Our ref: New Eileen O'Connor School (SSD-67173718)

10 September 2025

Subject: Response to Submissions – Department Key Issues

Flood Hazard Locations along Evacuation Route to Westfield Shopping Centre

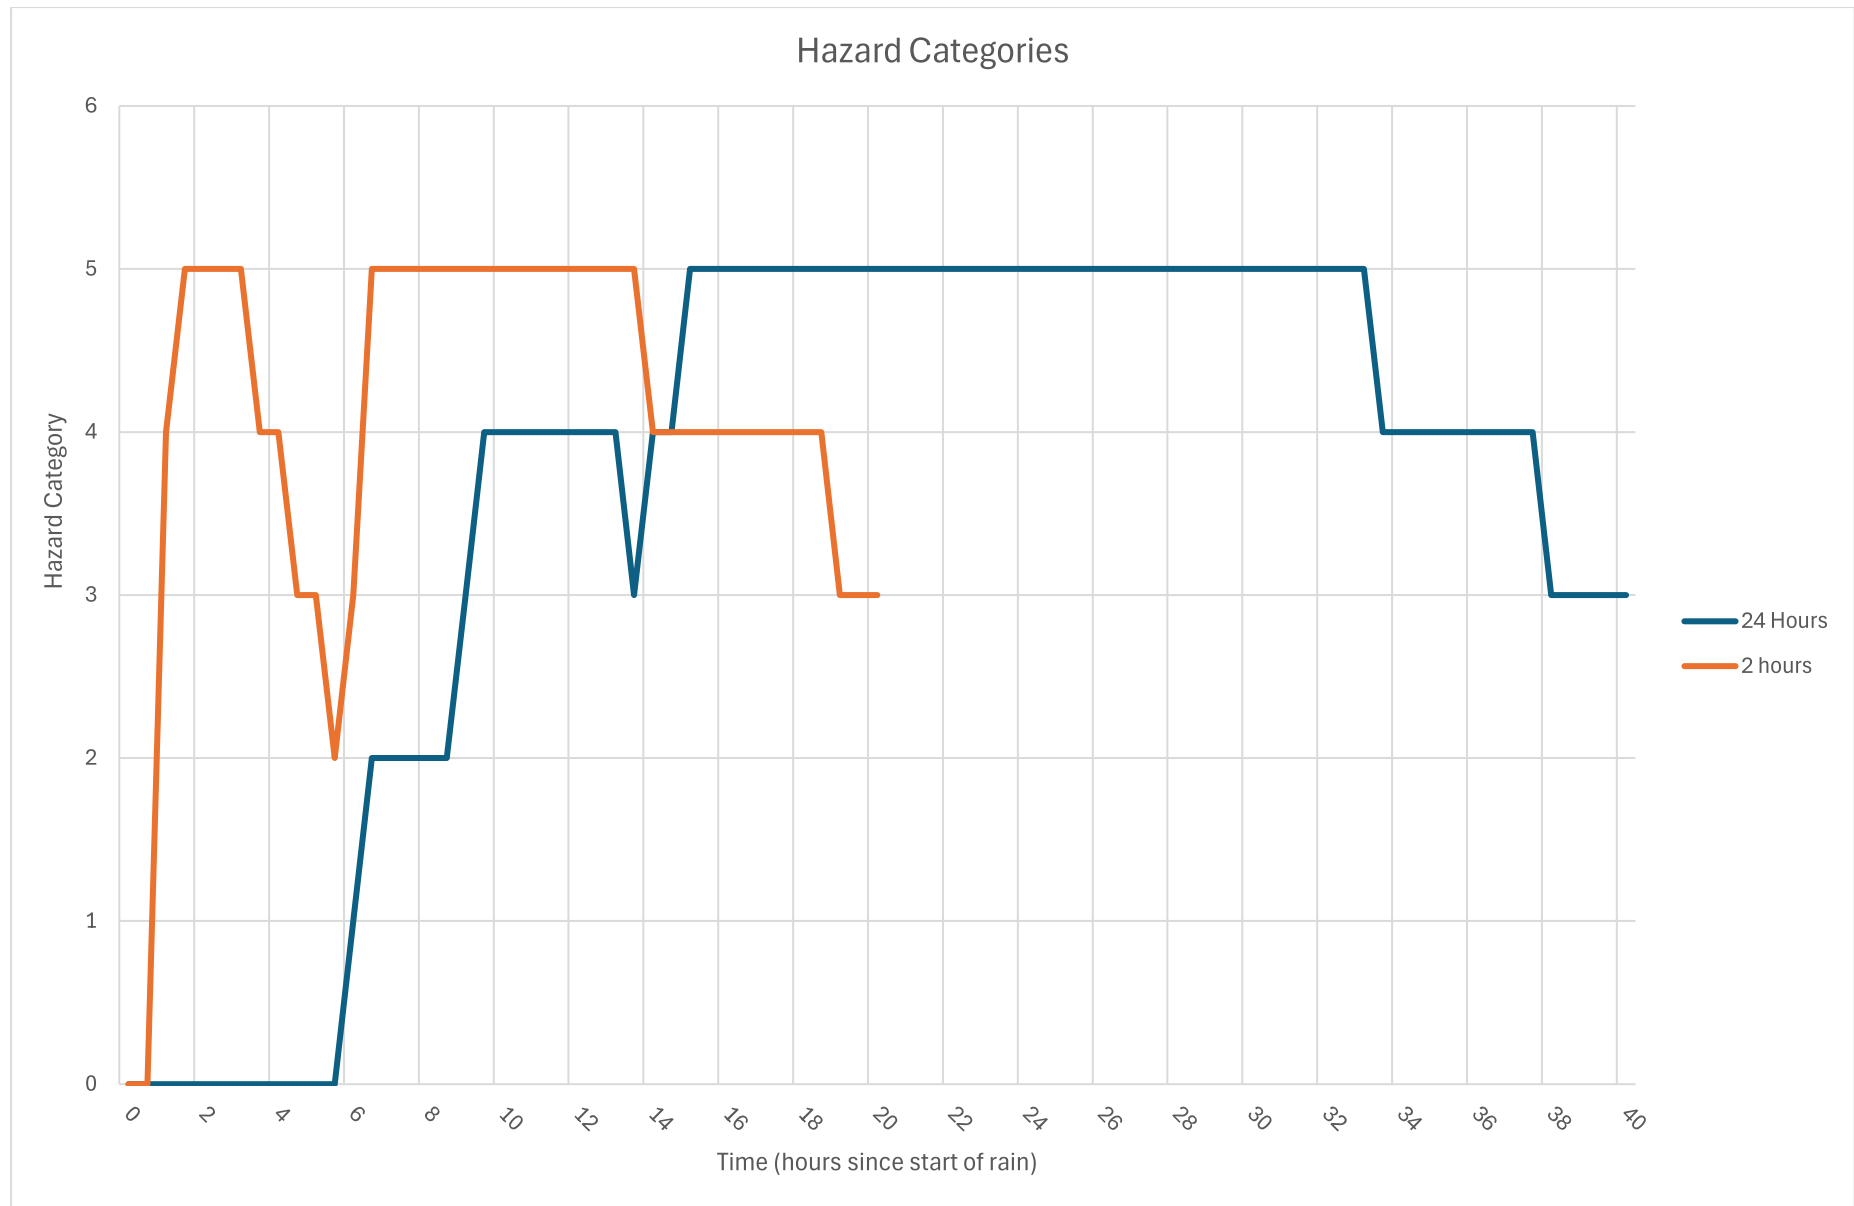
- The duration of the proposed shelter in place is potentially longer than 6 hours given the high hazard flooding impacts to roads in the surrounding area, particularly the intersection of Woodbury Park Drive and Wyong Road (Location B), which may remain at Hazard Level 2 for up to 12 hours (Attachment A of FIA) and would be impassable for small vehicles.

- The FIA and FERP do not demonstrate that the proposed evacuation, particularly given the specialised nature of the school, can be carried out in the timeframe required to ensure evacuation in flooding events prior to surrounding roads being impassable.
- The evacuation procedure relies heavily on the ASTP buses and private vehicles of staff and it is not clear if these vehicles would be readily available in an evacuation or have the capacity to evacuate the number of students on site (other documents note the ASTP buses as 2 x 12 seaters)
- Westfield Tuggerah carpark as an evacuation refuge is not suitable given this is not a recognised flood refuge, it is unclear what facilities would be available and there is no agreement with Westfield to use the site for this purpose.

**03 North Elevation**  
 1:200

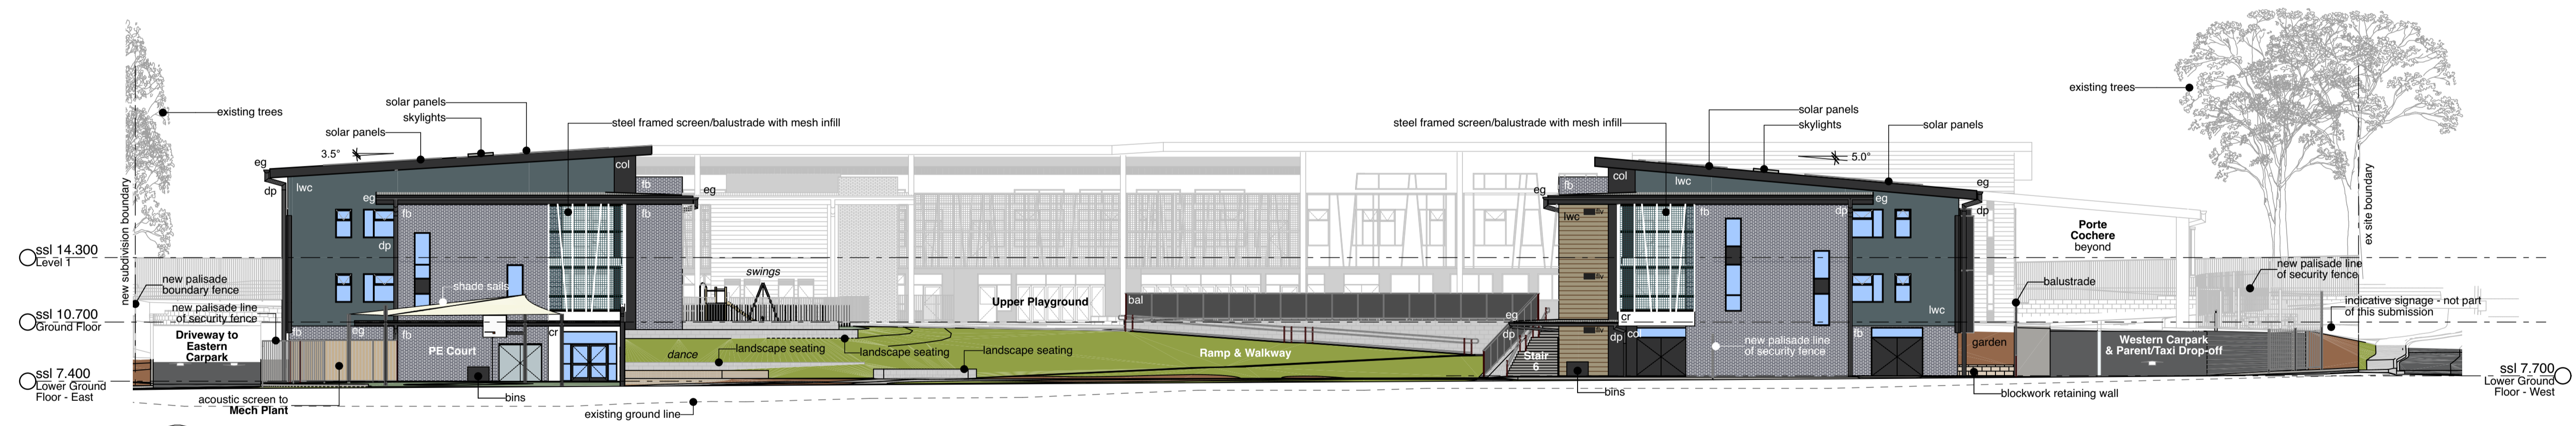
- The northern elevation of the western wing of the building presents a 3-storey form to the rear yard of the neighbouring residential properties. There is concentration of bulk at the northern boundary in this location given the 3-storey form, bus carport and acoustic fence and this impact presents unacceptable visual bulk to the small neighbouring yards.
